**WEST SUSSEX COUNTY COUNCIL  
STRATEGIC PLANNING CONSULTATION**

**SUBJECT: LU/104/13-Erection of a 3 storey building to create 3 x 1-bedroom flats.**

**1, Willow Brook, Wick, Littlehampton, West Sussex, BN17 7NW**

Proposed Floor Plans.

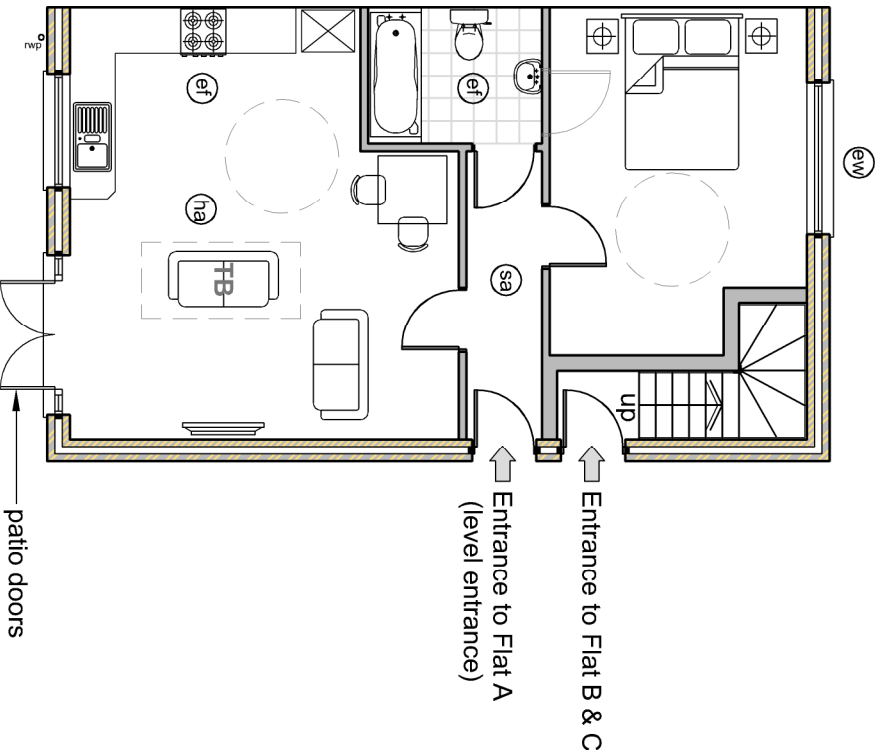
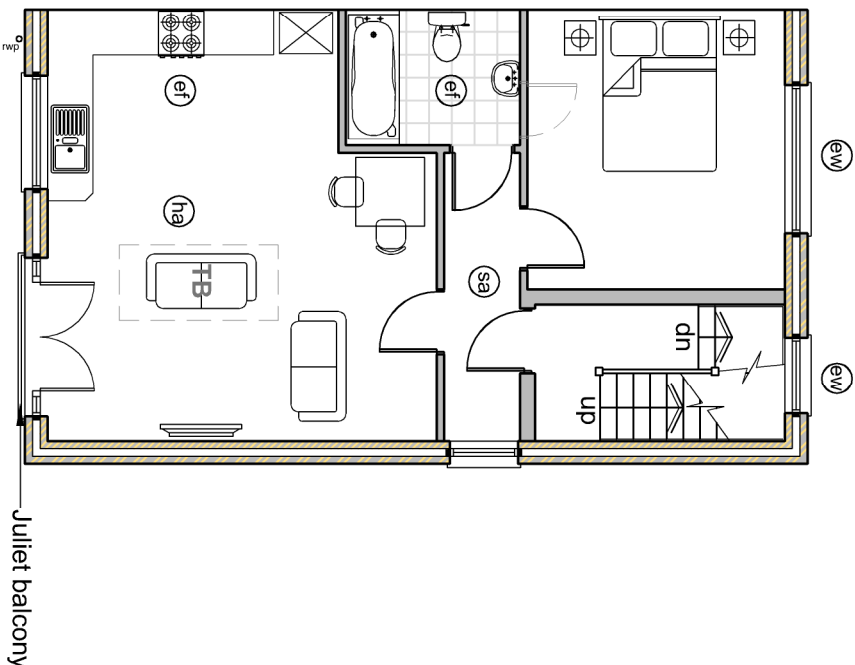
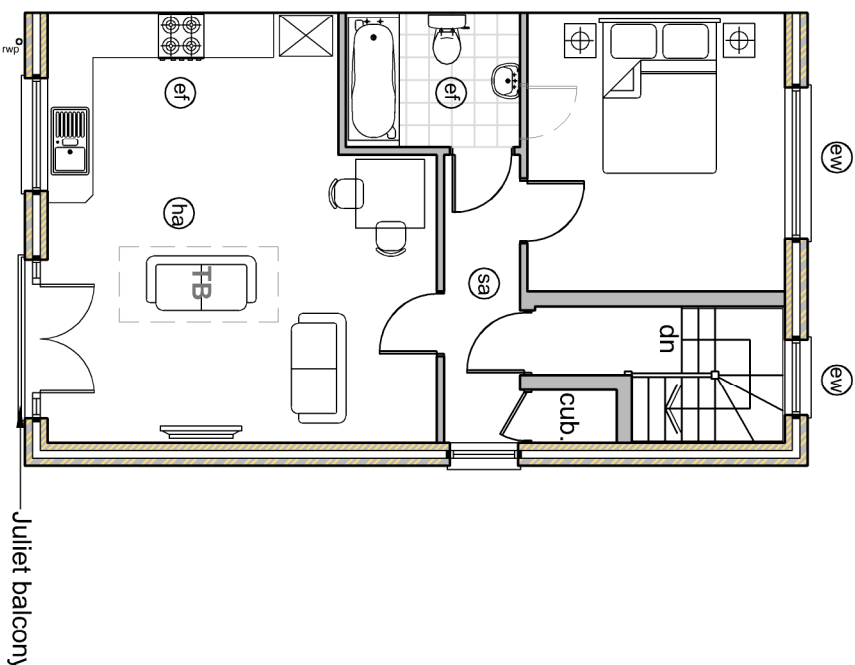
The proposal will have a nil parking provision. Through the nil parking provision there could be some additional on-street parking demands, no highway safety concerns would result, but the LPA may wish to consider the potential implications to the street scene. Cycle parking must also be provided for the flats. This facility should be covered and securable, details should be submitted to the LPA for approval.

If the LPA are minded to approve this application a condition securing cycle parking should be included.
